Jeanie Bourke - RE: 4 Canal Plaza

From: Jeanie Bourke
To: Benjamin Murray; Benjamin Wallace
Date: 9/21/2012 9:06 AM
Subject: RE: 4 Canal Plaza
CC: 'SteveHiggins'; Dan Catlin (dan.catlin@comprop-1.com)

## SECTION AT EXISTING CHASE

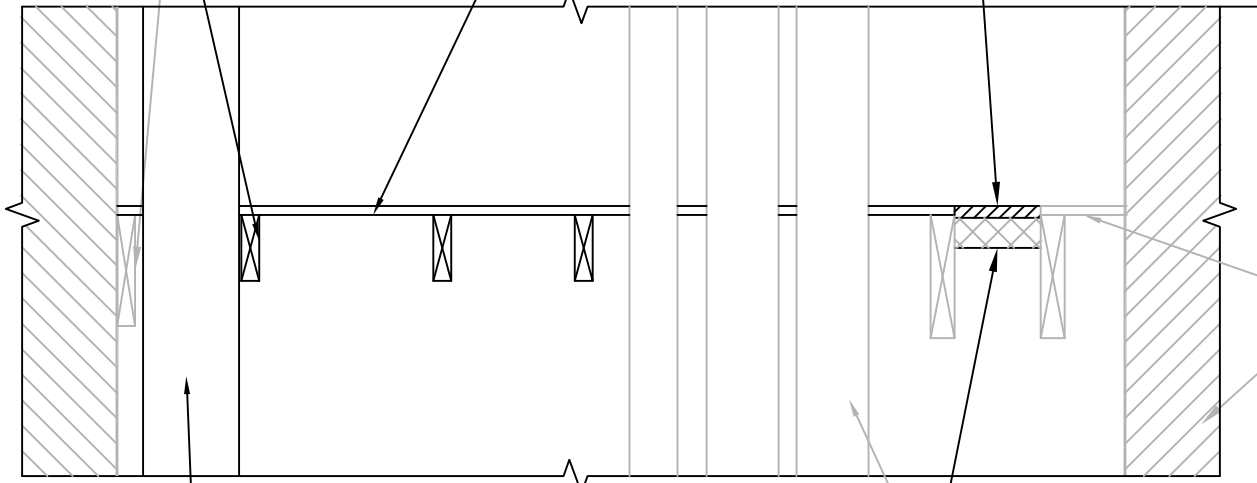
What came of the shaft enclosure that housed the new ductwork that we identified as not being built to your plan specifications for gypsum on the inside of the stud wall surrounding the shaft?

Ok, I do understand that you are not treating this as a shaft, but help me understand how this area will be treated as a horizontal assembly when there is no floor. This is a tight situation, but the insulation/compound has to be supported in place as well as the sleeve, I don't see how this can be achieved if there is no floor or deck.

Can you confirm how large the areas are without any floor (horizontal assembly)? The cross section should specify how the various areas will be framed in and decked and what the largest void space is to be filled. The product installation specs should provide the restrictions on the annular space to be filled.. Also, the space in the sleeve needs to be treated as well as around the sleeve. There are UL design listings for these fire/smoke systems

I may be missing something, but while these products meet the standards and testing, I'm not sure the application is correct. If I recall, the area this is proposed to be installed is a shaft, there is no floor/deck surface that the pipes, wires, conduits are penetrating. This material can only fill in the annular space or void around the penetrations of non-combustible items and perimeter voids. These products cannot fill the whole area where there is no floor or slab.

This is either a shaft or a floor with through penetrations, from what I can see on the cross section, there is no floor in the area of the penetration. What is going to hold the material in place or the sleeves in the case of combustible pipes?

I went to the site yesterday after receiving your email to take another look at the chase and take some measurements. Since our first site meeting, Dan's contractors have cleaned out the chase of all of the unused conduits, ductwork and piping and it is substantially cleaner. I have also revised and added additional details to my drawings. I am showing new floor construction to maintain the horizontal assembly throughout the space. The floor sheathing will be scribed around the existing conduits and pipes and then sealed with fire caulking. We will bunch the electrical wires together and provide a metal sleeve that will attach to the floor sheathing. This will get fire caulked as well. We are proposing to use the packing material and smoke seal in locations where we cannot fit in floor sheathing. These locations are small in width and can be packed easily with the

material. I did find some literature that the packing material can go up to 8" in width. I believe our greatest void width is approximately 3" to be filled behind the steel column. Please review the attached updated sketches and pictures taken of the chase yesterday. Thanks.

Thanks for getting back to us. Where the Owner is going to be sprinkling the entire building now, we are treating it as a horizontal assembly (Section 708.2 (3) & 713.4). With multiple penetrations, we would like to span between the conduits with this firestop system (Section 713.4.1.1.2). The installation of an actual floor in this space would be nearly impossible due to the configuration. I agree that at any locations where a floor can be installed, it should be and Dan has had his contractor do that. They are looking to remove some more of

the old ductwork that isn't being used and that section will be infilled with flooring. The sleeves will be installed around any non-metal conduits and then the insulation will be installed in between the conduits. The insulation or packing material as it is called is cut slightly larger than the opening and is rigid to fit tightly in the space. Once installed, the smoke seal compound is installed on top. When complete, the enclosure provides a rated smoke tight enclosure. As discussed, I will be on hand to observe the install of the packing material prior to the install of the topping compound. Let me know if this did not answer your questions. Thanks.

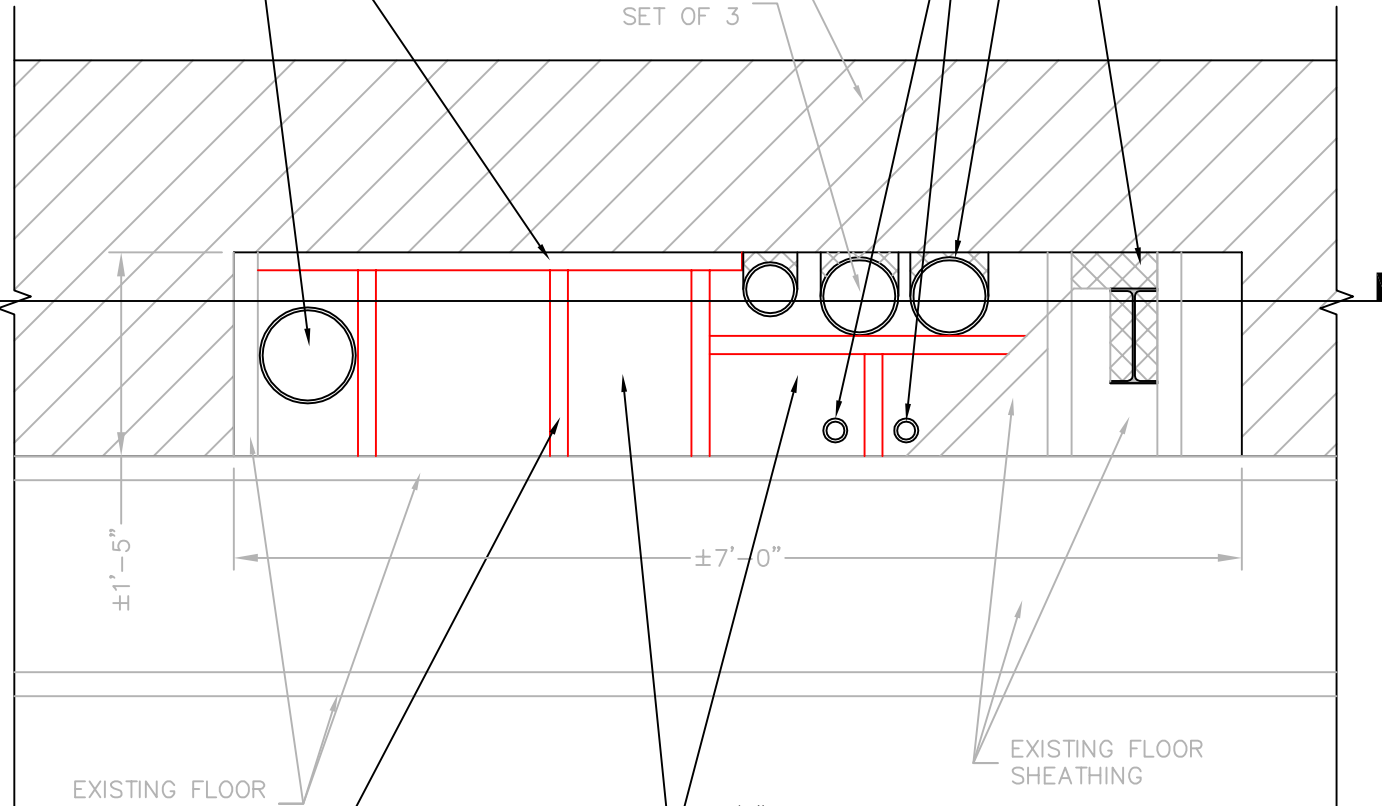
I do not have a problem with this method but would call to you attention that it is for use around steel and metal piping. It does not indicate its suitability for use around PVC pipes. I suspect you'd need listed collars for those. I've CC'd Jeanie for her consideration too.
